PLANNING APPLICATION CONSULTATION RESPONSE

Application Number:	3/2023/0754
Proposal:	Proposed change of use of agricultural land to new car park and storage yard.
Location:	Judge Walmsley Mill Longworth Road Billington BB7 9TP

The Lead Local Flood Authority **objects** to the above application on the basis of:

dwg purpose  
Proposed Car Park

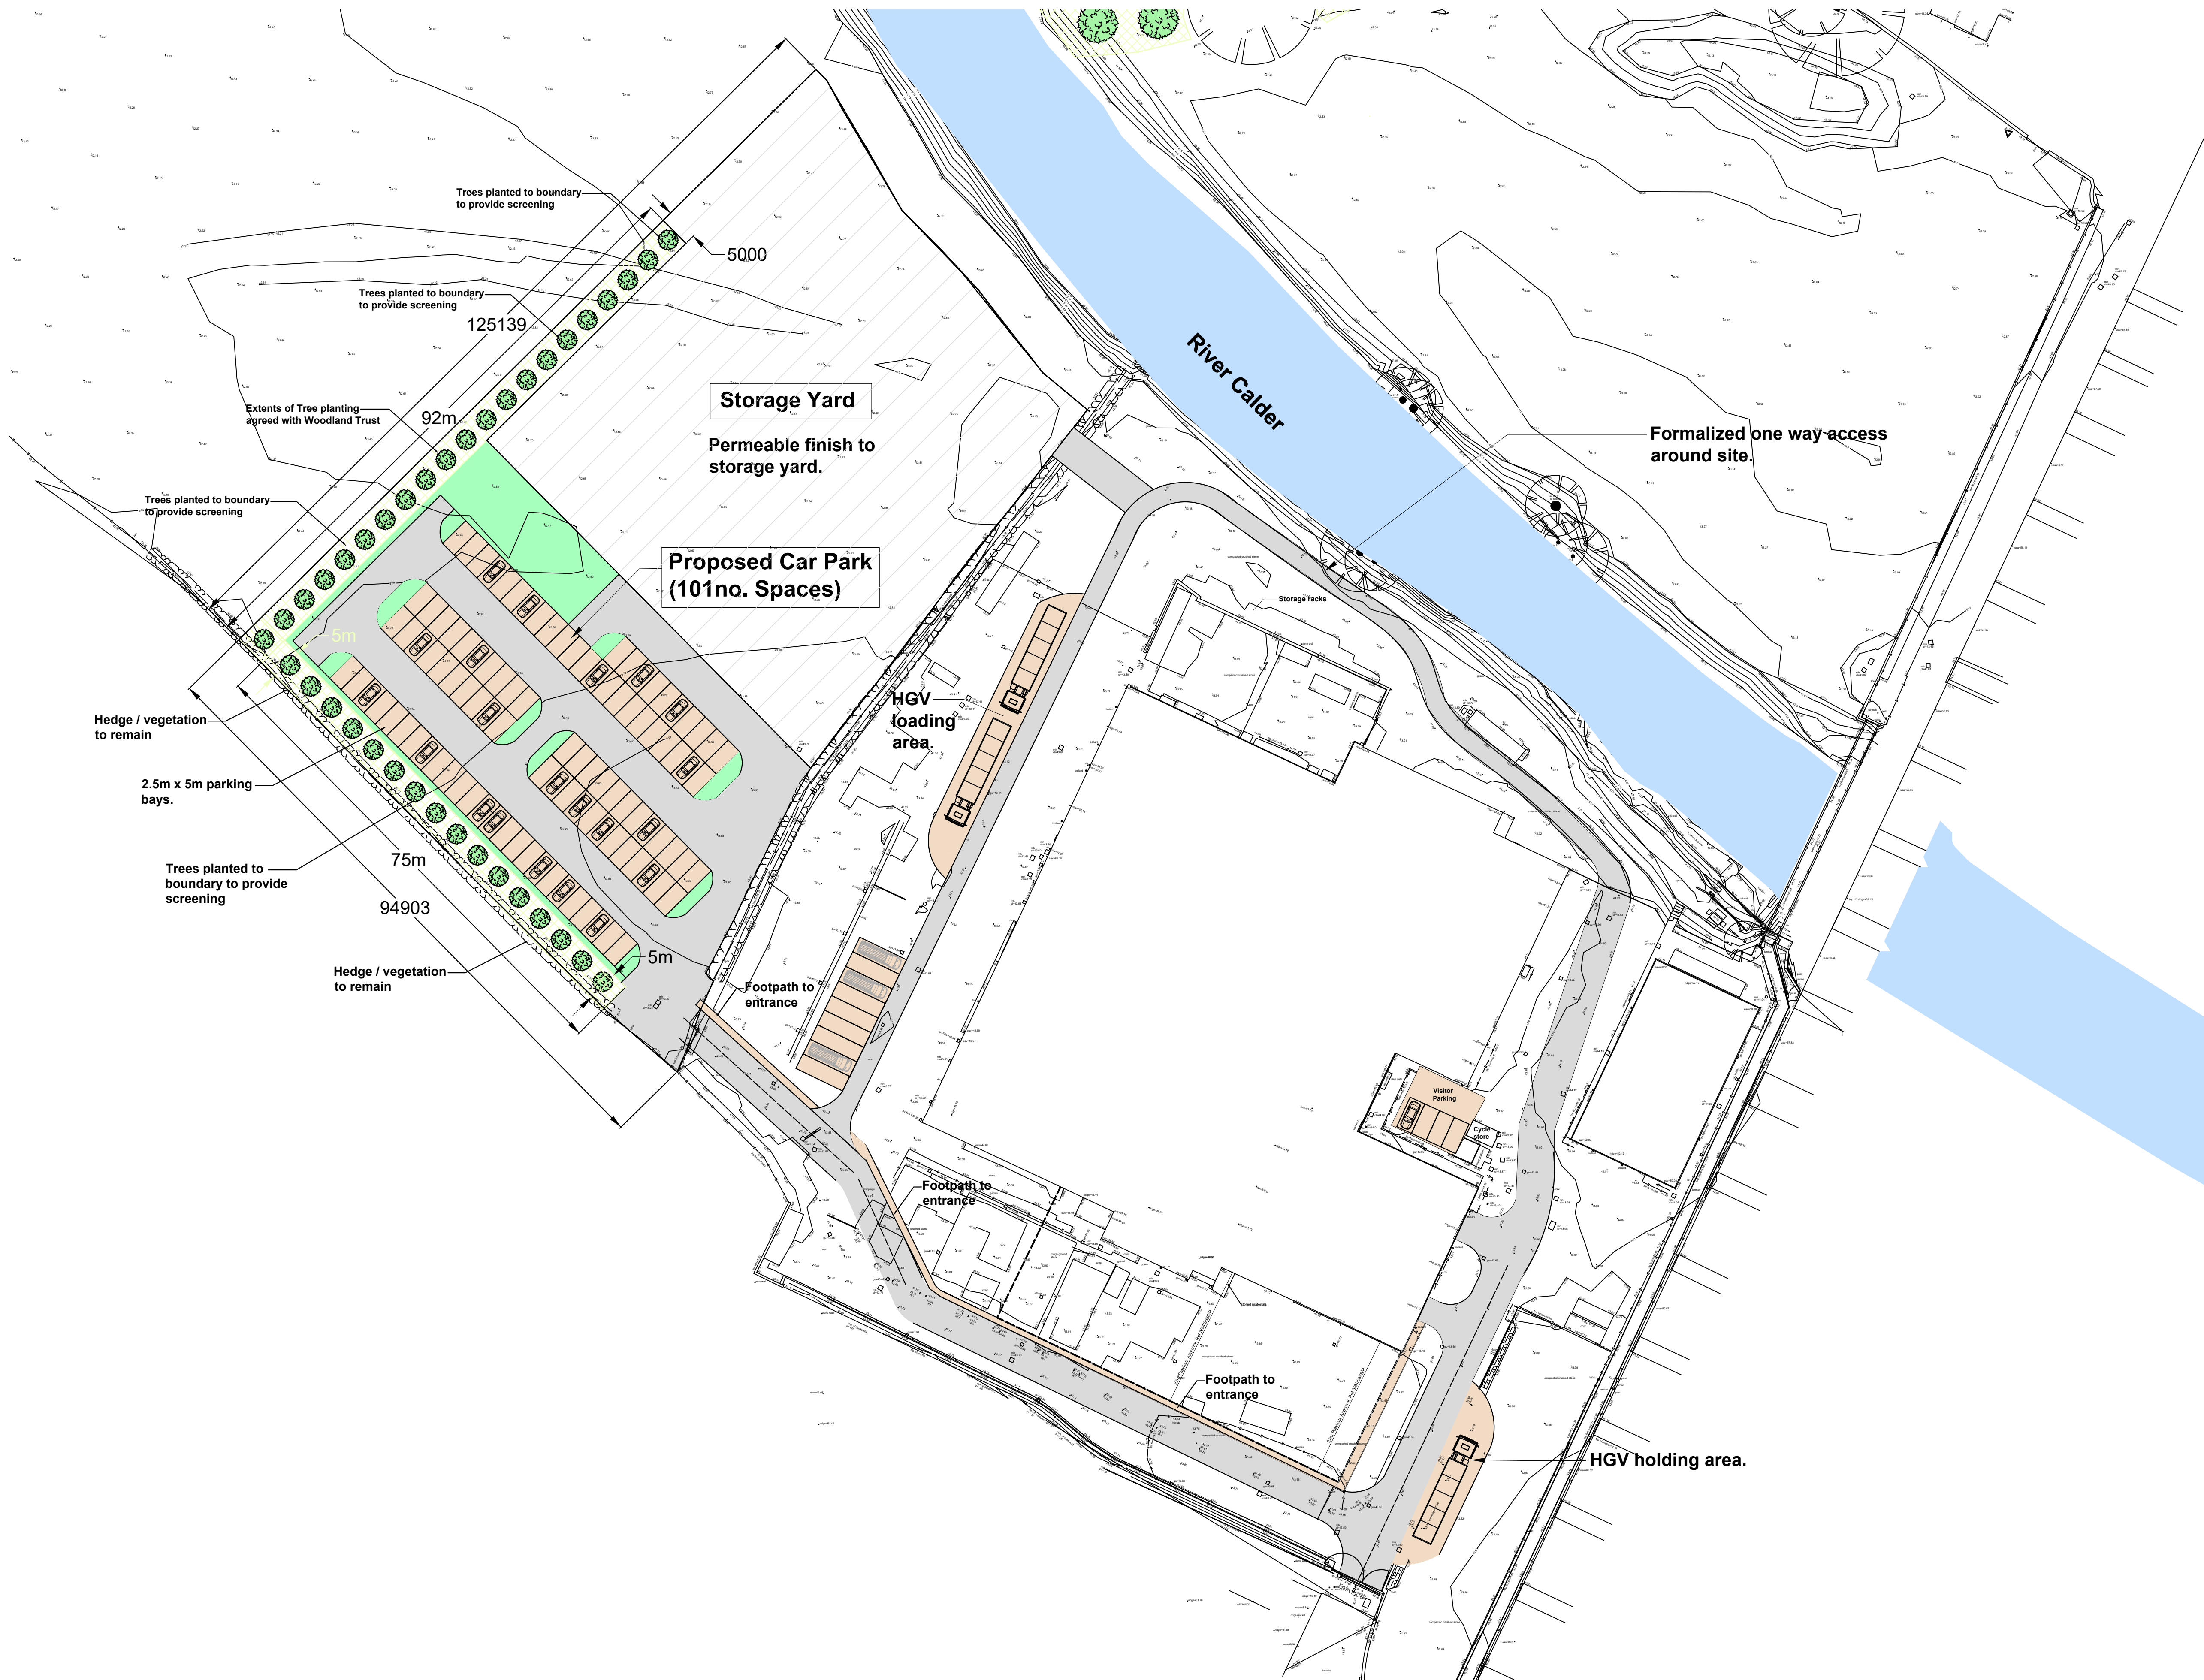
The Lead Local Flood Authority recognises the applicants reference that the carpark will be constructed using permeable paving, however, without evidence of a surface water sustainable drainage strategy or evidence of the permeable paving to be used in order to ensure its feasibility as well as how it will function in the event of a flood or a high ground water table. If the applicant is unable to provide the appropriate evidence of the feasibility of permeable paving at this point in the application process, the applicant should provide a 'plan b' option for appropriately draining the development area.
